Substantive response of the Local Highway Authority to a planning consultation received under The Development Management Order.

Planning Application Number: 22/0570/FUL

Application Address: Holly House Farm Forest Road Huncote Leicestershire LE9 3LE

Conversion of sheds to dog daycare facility and kennels and conversion of stables to boutique kennels

Speed Survey

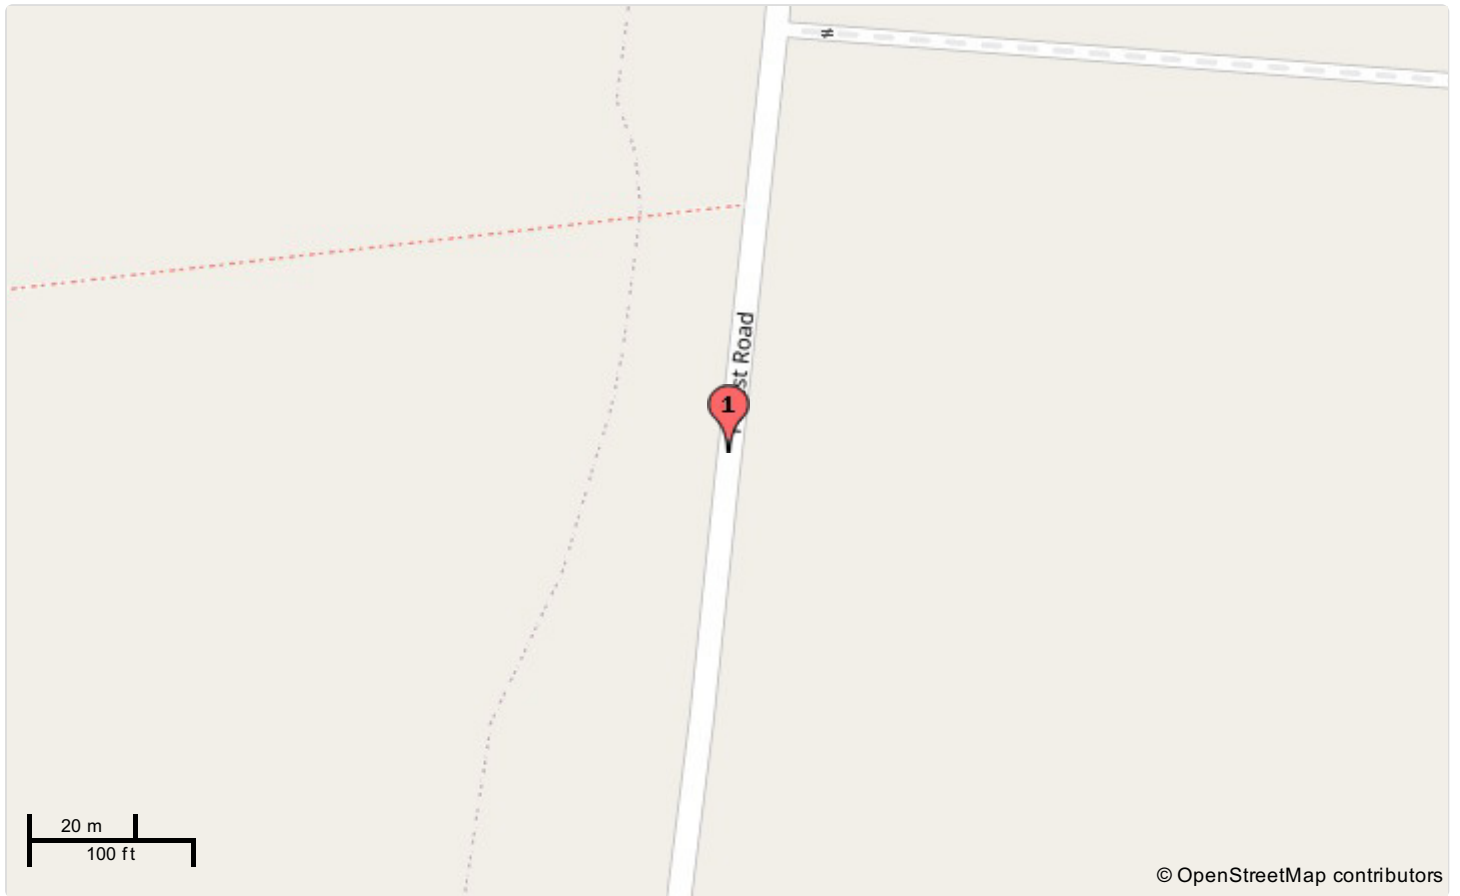
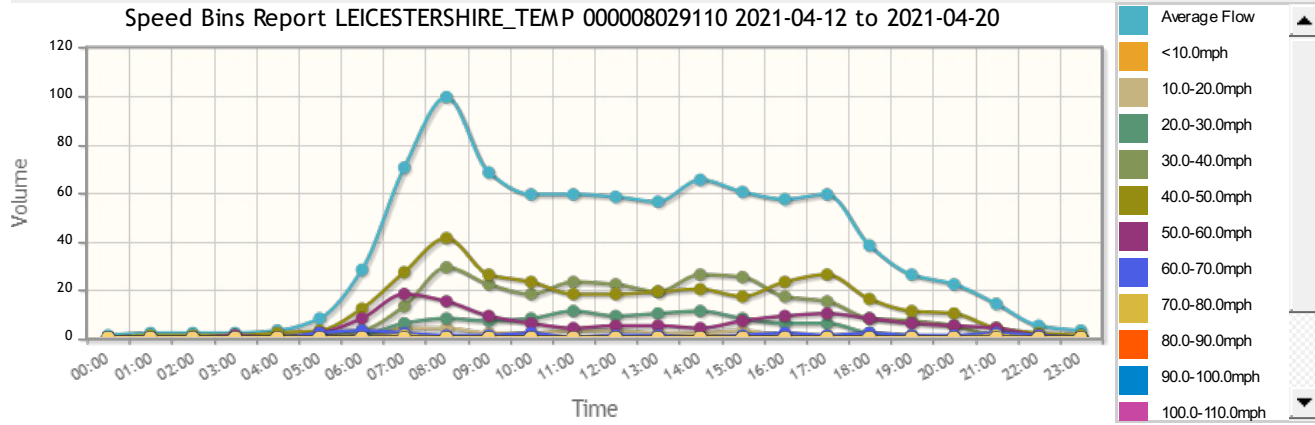
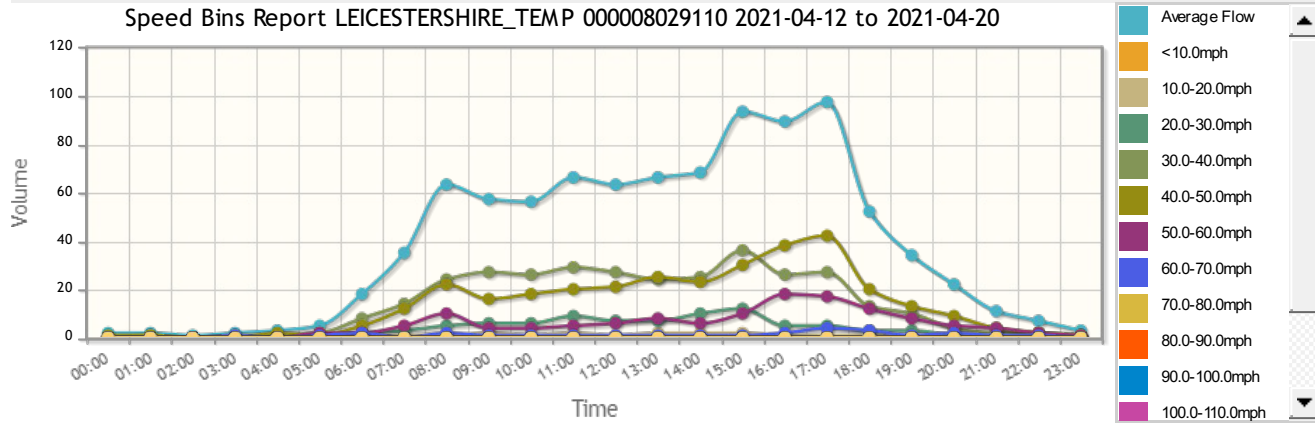
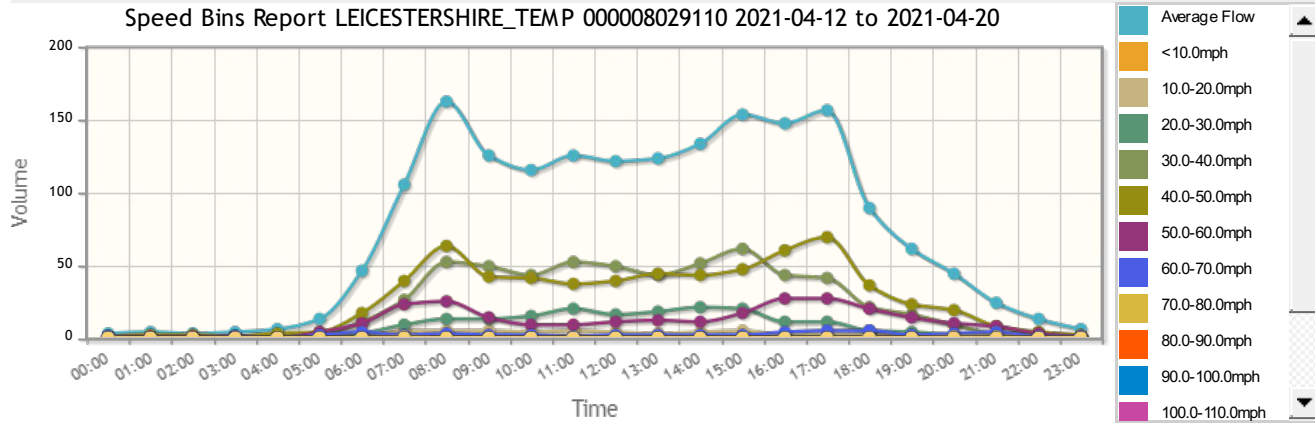
The LHA are satisfied that the proposed visibility splays of 160 metres from a setback distance of 2.4 metres are sufficient. These splays are based on the results of speed survey undertaken south of the site access between 12 April 2021 and 20 April 2021 that recorded a northbound 85th percentile speed of 51.1 mph and a southbound 85th percentile speed of 50.9 mph.
